KIRKLEES METROPOLITAN COUNCIL INVESTMENT & REGENERATION SERVICE

DELEGATED DECISION TO DETERMINE PLANNING APPLICATIONS

Reference No:	2021/62/90126/W
Site Address:	Coachways, 1a Dingley Road, Edgerton, Huddersfield, HD3 3AY
Description:	Erection of extensions and alterations to existing coach house to form annexe accommodation associated with Coachways, 1a Dingley Road, Edgerton, Huddersfield, HD3 3AY and partial demolition of existing bungalow with re-build to form 2 storey dwelling (within a Conservation Area)
Recommending Officer:	Ellie Worth

DECISION – Conditional Full Permission

Drawn	SJG
Date	15.02.11
Scales	1:50 & 1:100 @ A1
Drawing No.	20/D68/03
Rev.	D

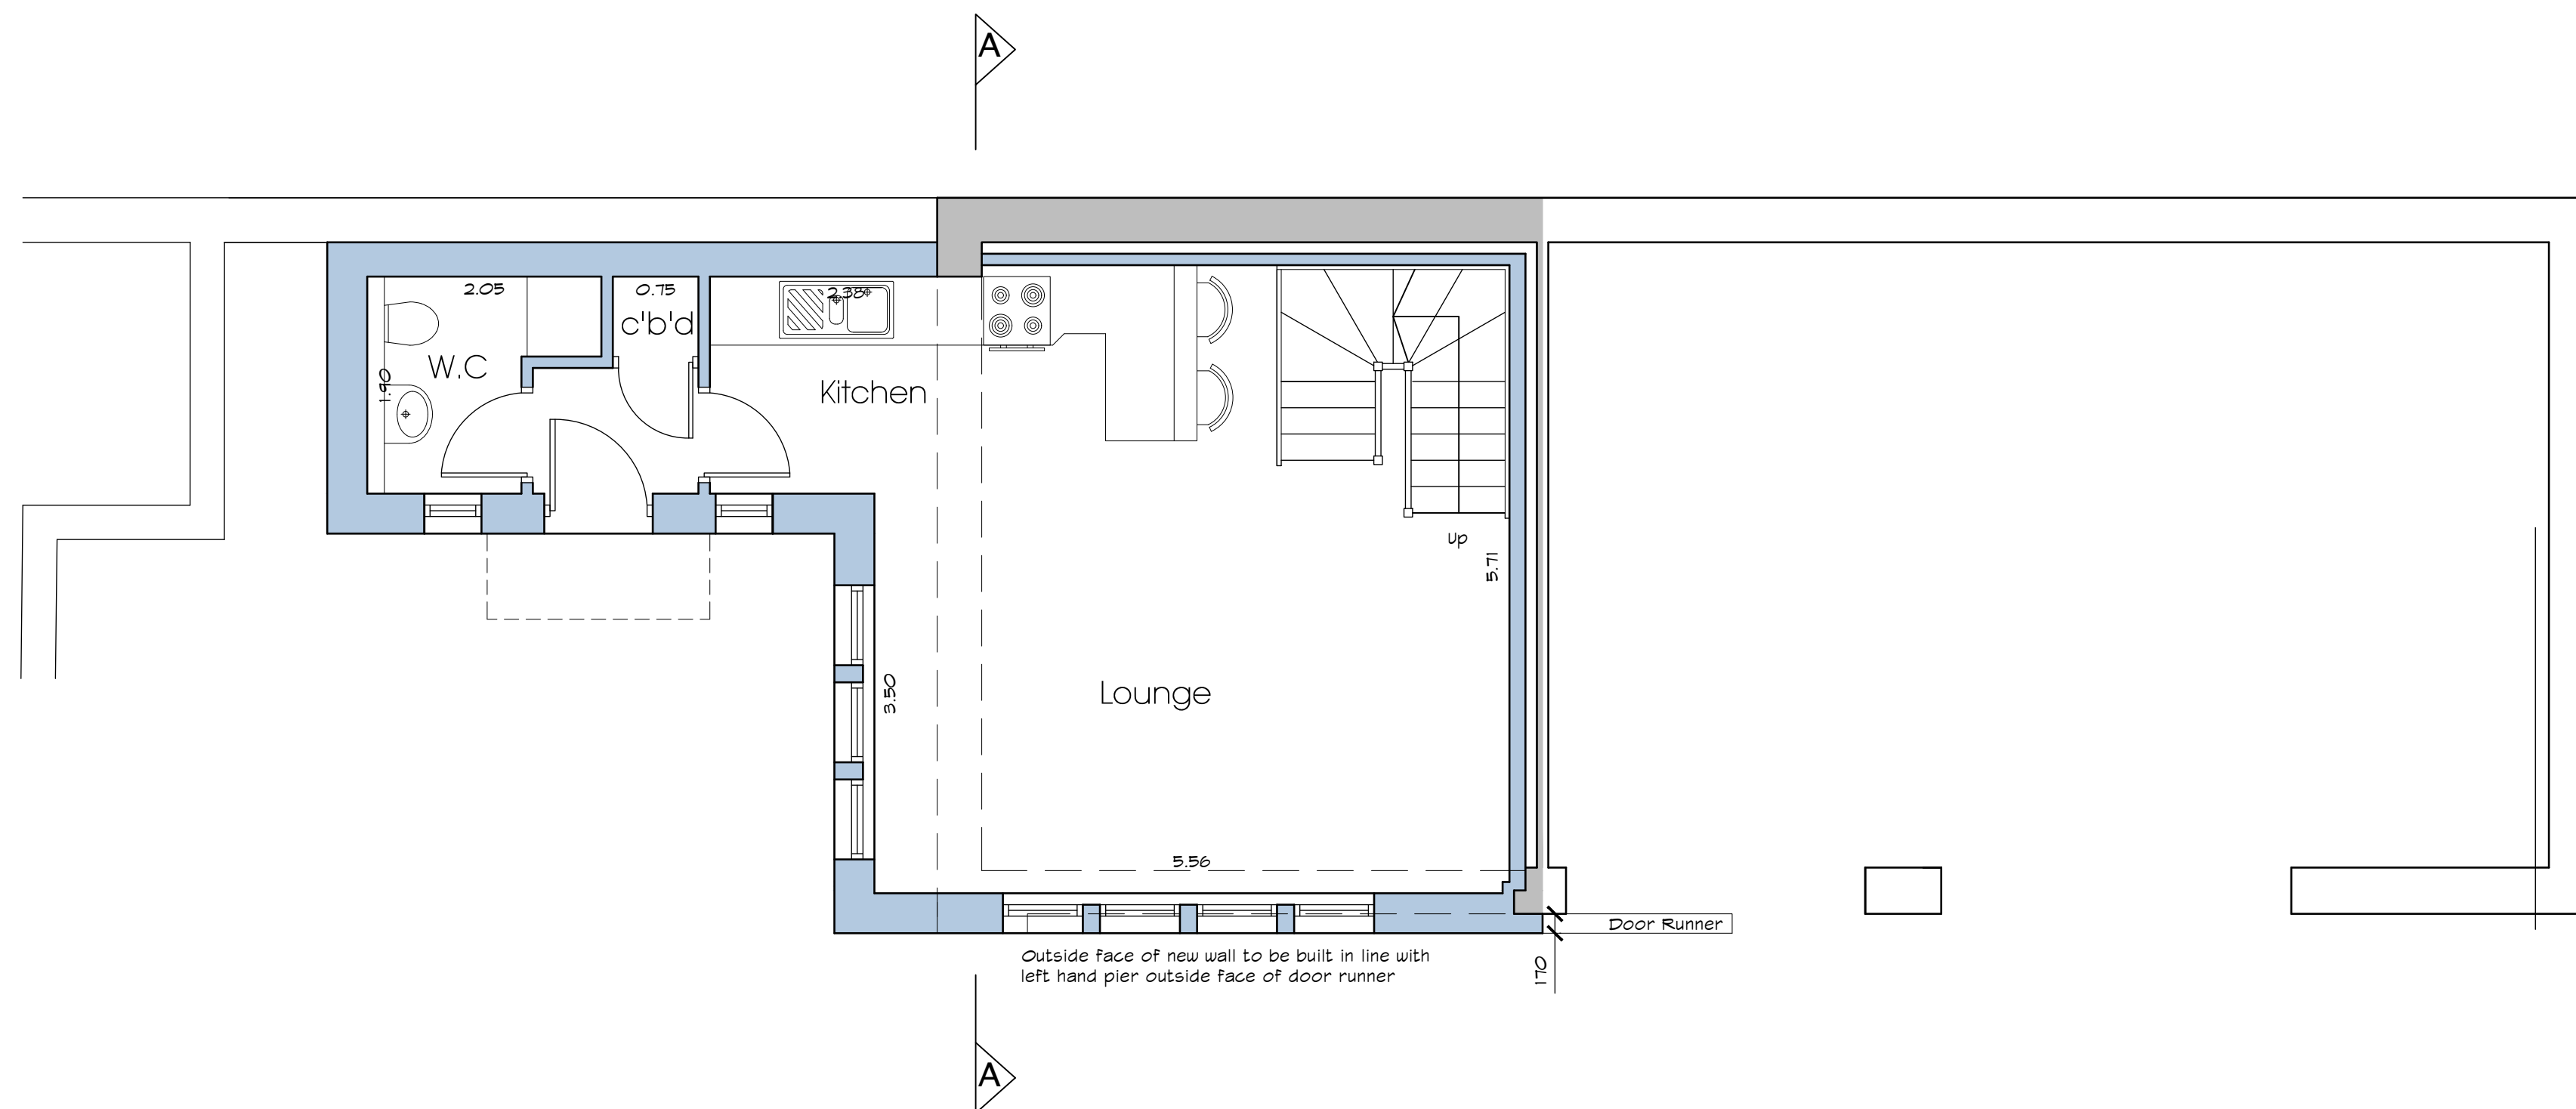
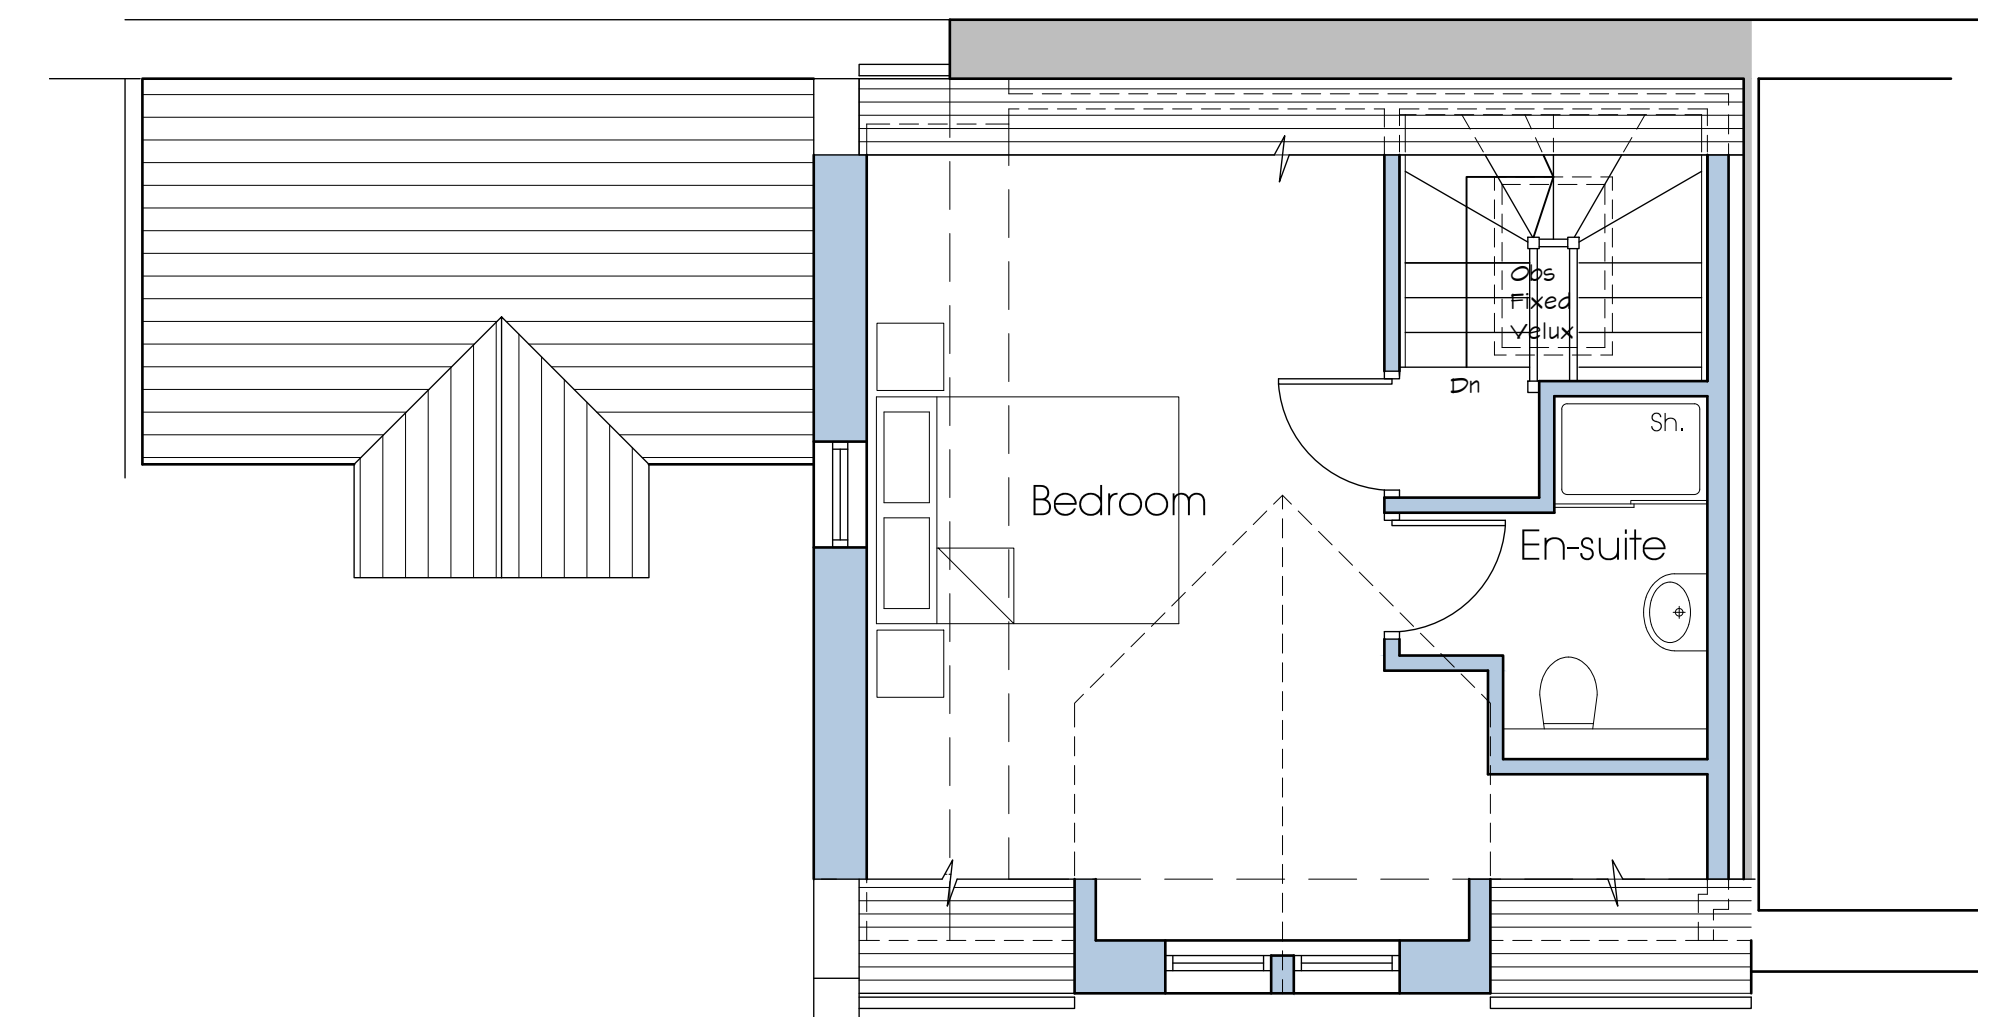
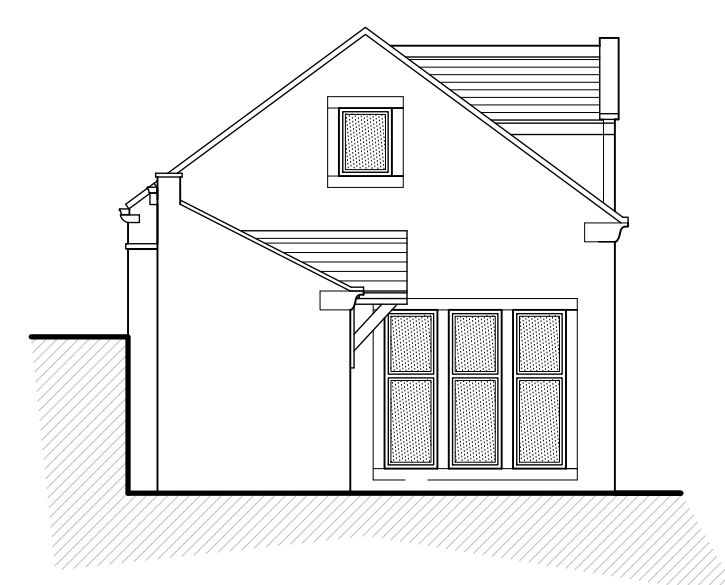
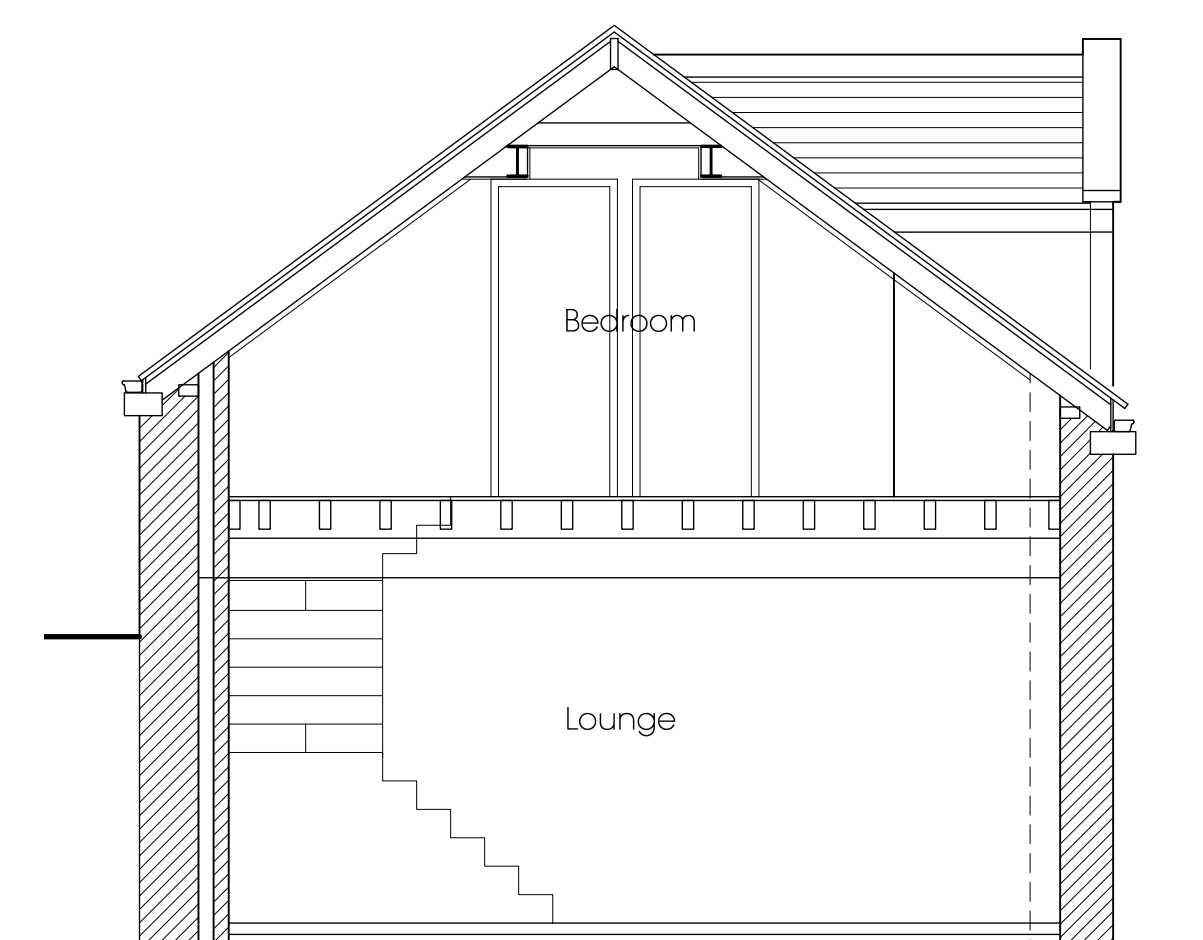
Members in this case, resolved to approve the application. This was with the imposition of an additional planning condition requiring the dormer window in the first floor front elevation of the coach house annex to be fitted with obscure glazing. This is to ensure the protection of residential amenity (privacy) given the relationship of the annex with no. 1b Dingley Road. As the annex does not form primary habitable accommodation and is simply an annex to the main dwelling, this condition is considered reasonable.

9. Notwithstanding the details shown on submitted plan ref 20/D68/03 Rev D, the dormer window, to serve the bedroom within the annex accommodation as indicated in the south east elevation hereby approved, shall be fitted with obscure glazing, minimum of Grade 4. Notwithstanding the provisions of section 55(2)(a)(ii) of the Town and Country Planning Act 1990 and the Town and Country Planning (General Permitted Development) (England) Order 2015 (or any Order revoking or re-enacting that Order with or without modification) the window shall thereafter be so retained obscure glazed.

Drawn	SJG
Date	19.09.13
Scales	1:200 @ A1
Drawing No.	20/D68/01
Rev.	H

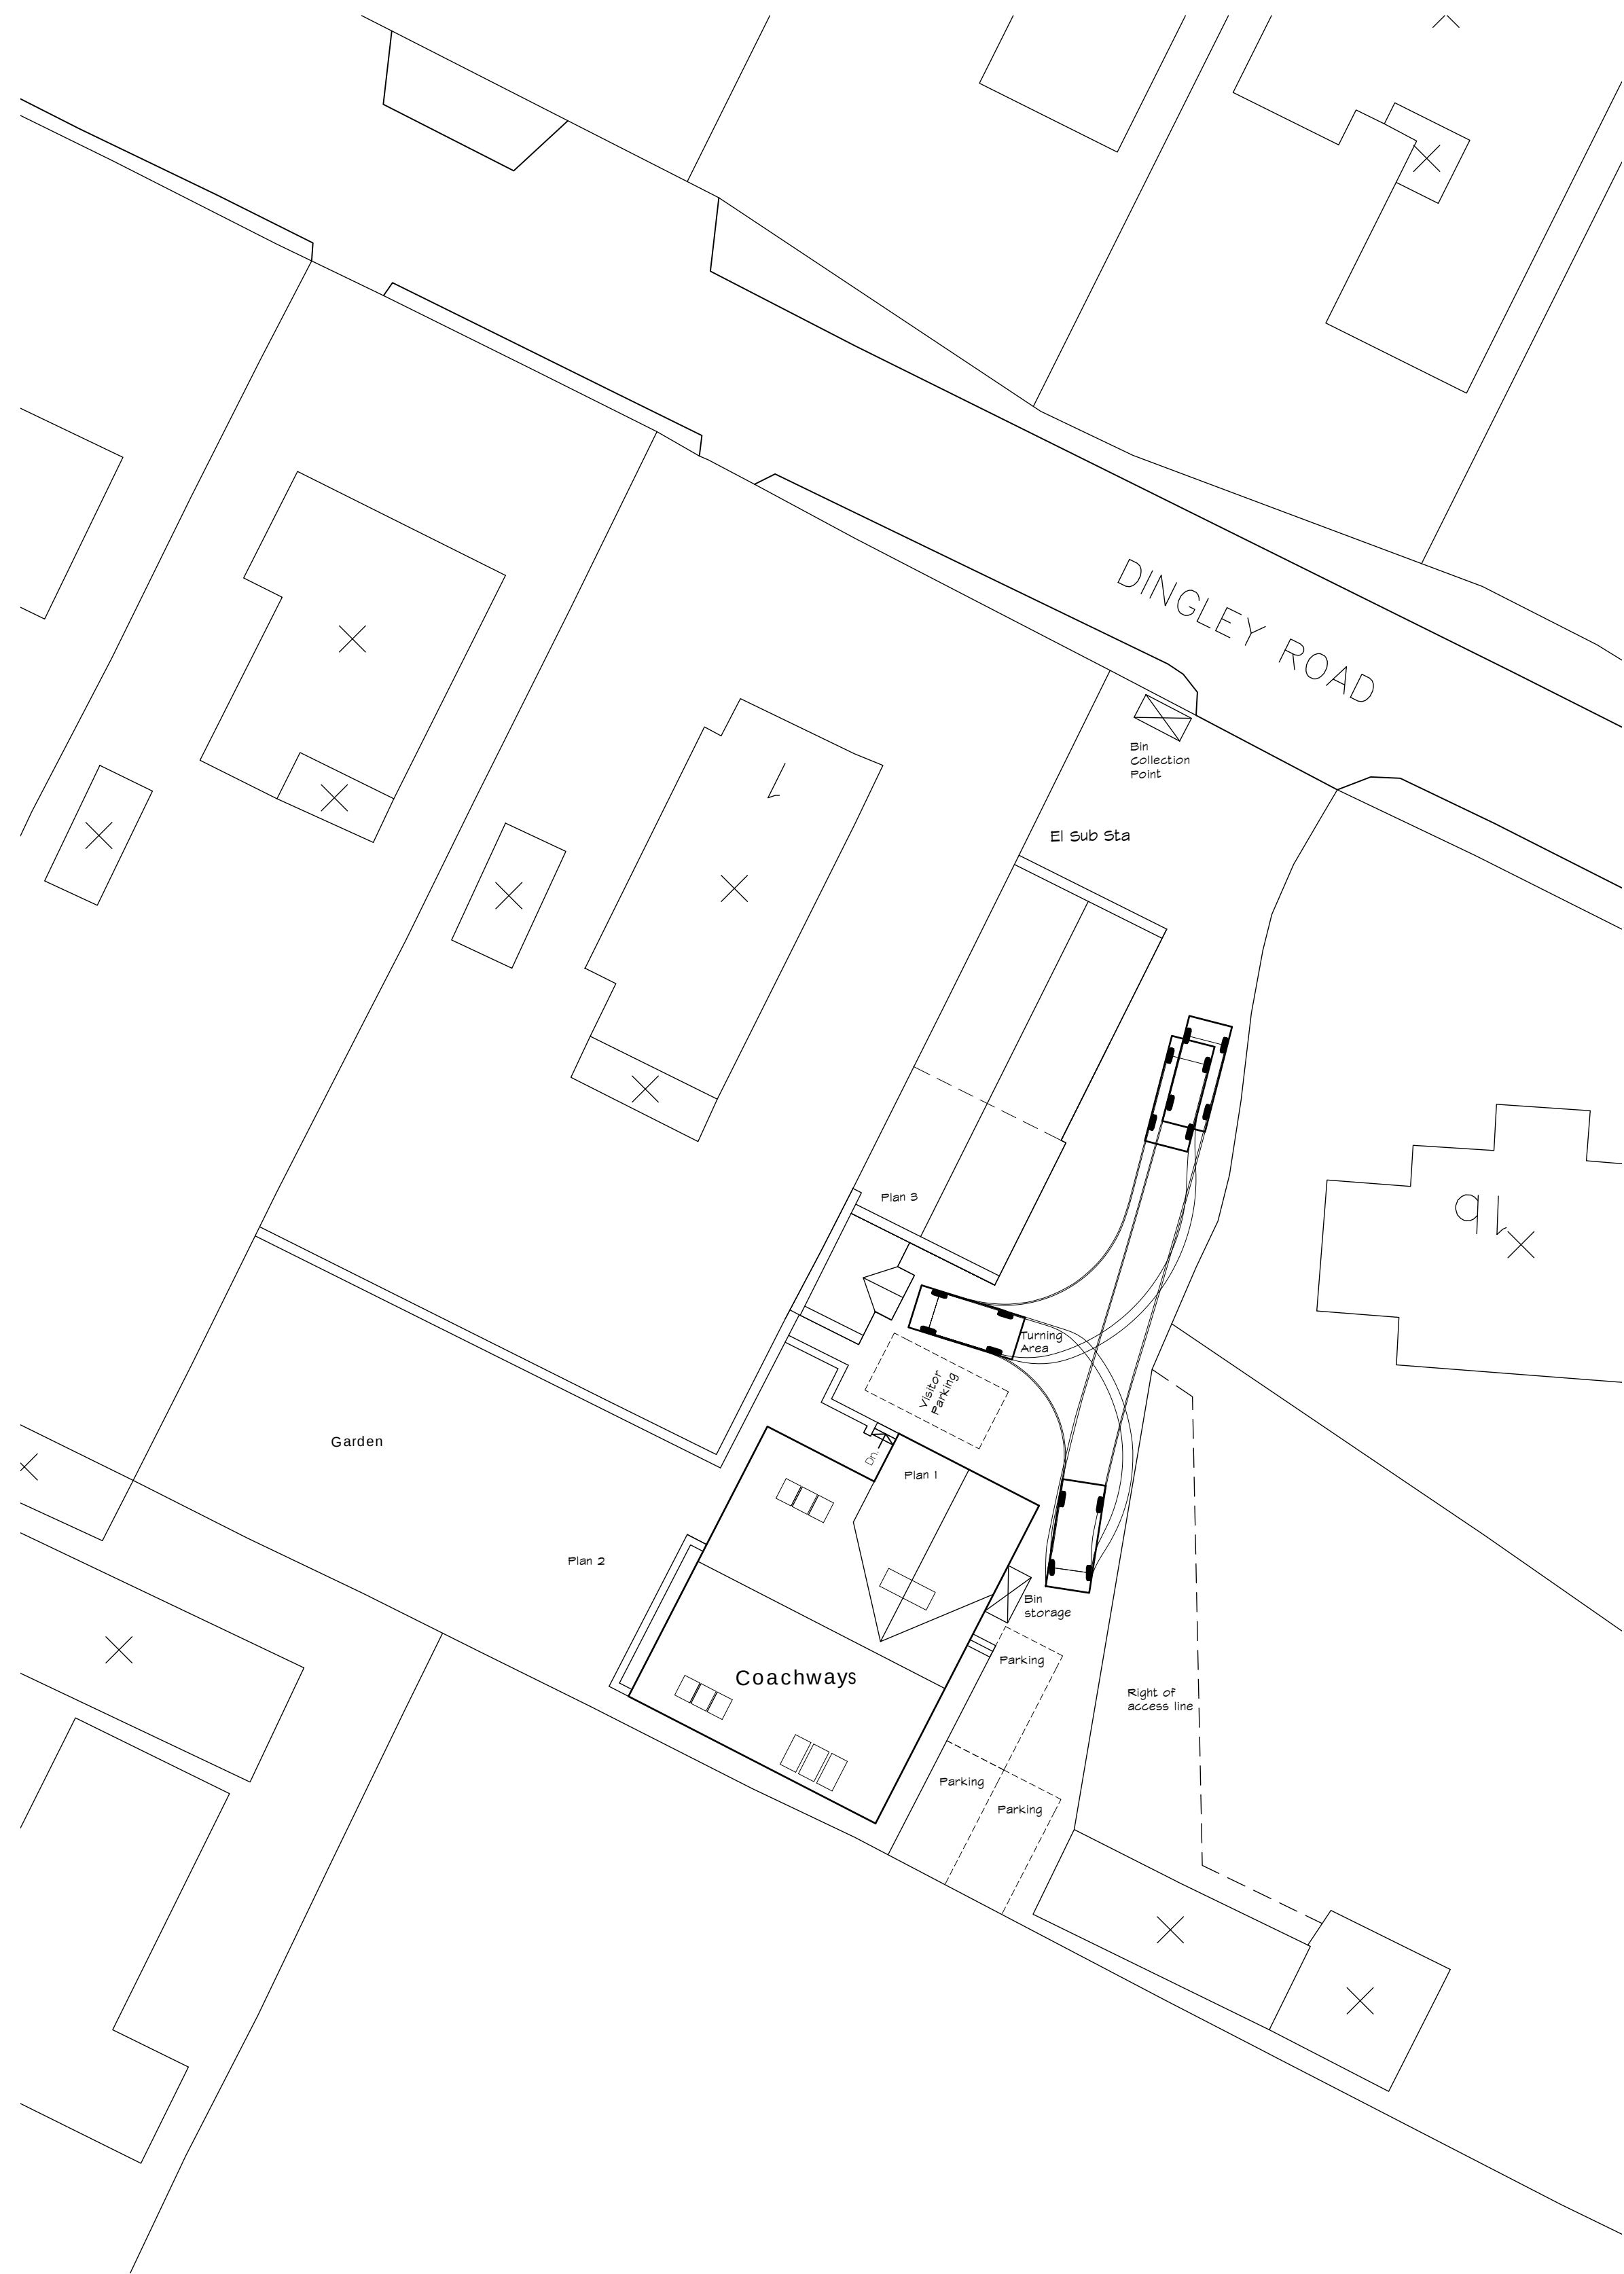
6. Before the re-built dwelling 1a Dingley Road is first occupied, one electric vehicle recharging point shall be provided in the parking area, as shown on the hereby approved site plan (dwg. no 20/D68/01 Rev H). Cable and circuitry ratings shall be of adequate size to ensure a minimum continuous current demand of 16 Amps and a maximum demand of 32Amps. The electric vehicle charging point so installed shall thereafter be retained.

8. The new driveway as indicated on the hereby approved site plan (dwg. no 20/D68/01 Rev H) shall be laid out with a hardened and drained surface in accordance with the Communities and Local Government; and Environment Agency's 'Guidance on the permeable surfacing of front gardens (parking areas)' published 13th May 2009 (ISBN 9781409804864) as amended or any successor guidance; Notwithstanding the provisions of the Town and Country Planning (General Permitted Development) (England) Order 2015 as amended (or any Order revoking or re-enacting that Order) this shall be so retained, free of obstructions and available for parking.
